An  
Bord  
Pleanála

## Inspector's Report ABP-302769-18

Whether the conversion of ground floor office space to a two-bedroom apartment is or is not development or is or is not exempted development

Tí Choinn, Gleann na Rí, Murrough, Co. Galway.

File Ref: Subject: 3.09 Existing building - Plans, Elevations & Section
 Project No: 18161
 Drawing No: 3102
 Rev. 1
 O'Neill | O'Malley Ltd.
 Architecture + Project Management

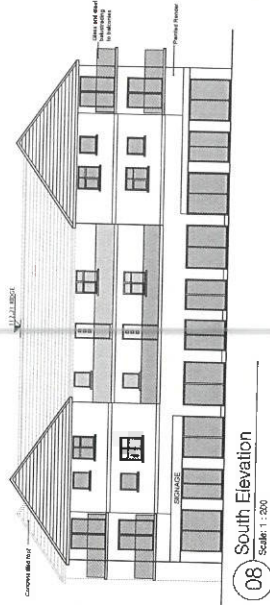
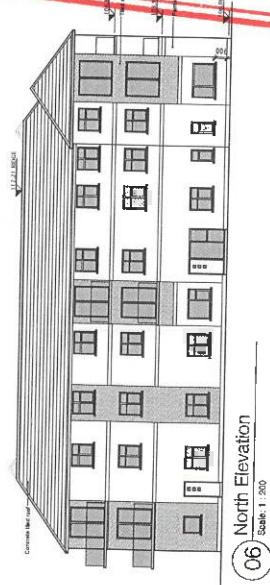
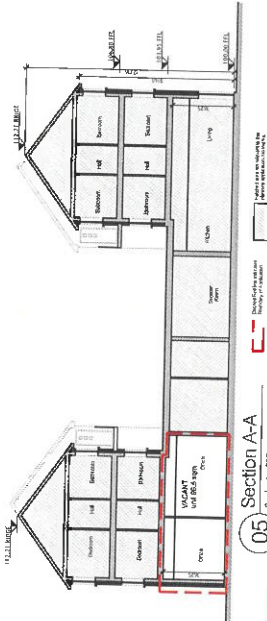
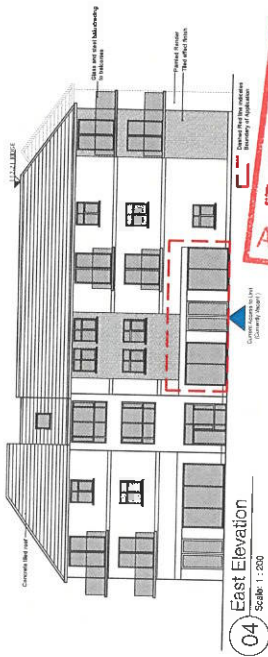
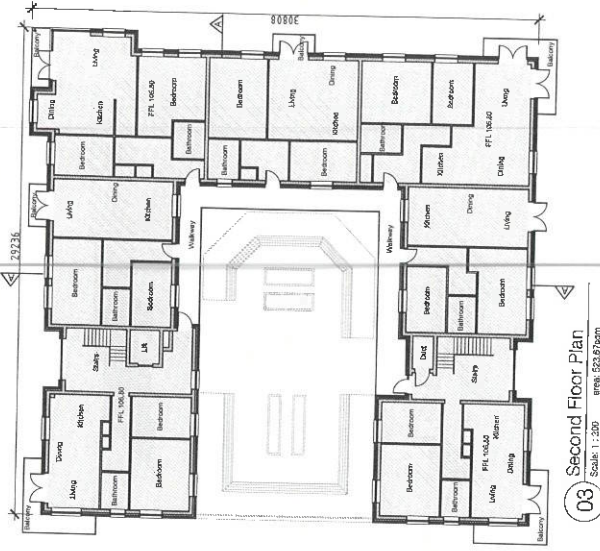
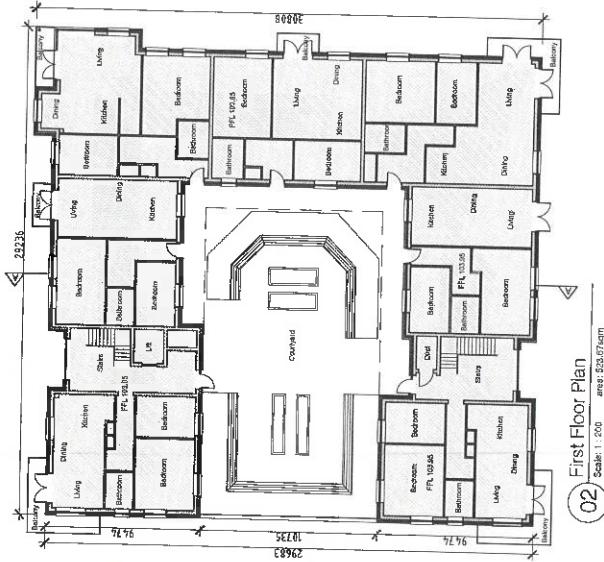
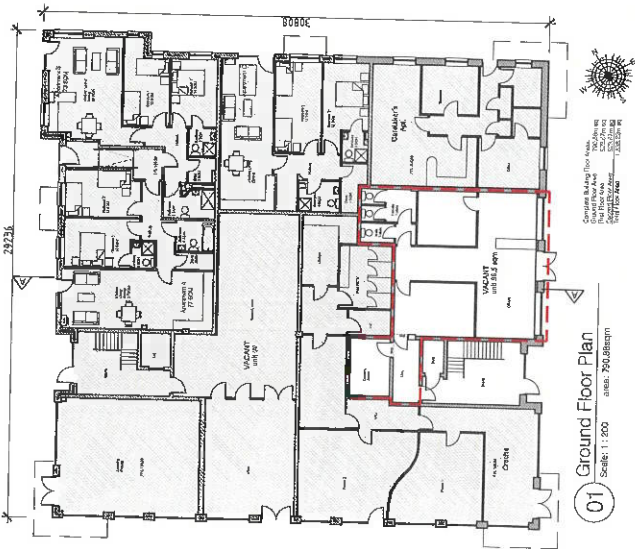
- Re 6(d)(ii) – they note that the works have commenced and they consider that the external changes, now complete, involve significant reduction in glazing, materially affecting the external appearance of the structure, and are inconsistent with the adjoining creche.

- 8.2.20. From the plans provided, it appears that the single kitchen/dining/living room proposed, (a habitable room being a room used for living or sleeping purposes but does not include a kitchen that has floor area of less than 6.5 square metres) would not have adequate natural lighting.

- 8.2.21. The proposed utility room is an internal room, of 8.53 sq m, which would have no natural light and no window, being of greater area than 6.5 square metres this would also de-exempt the change of use.
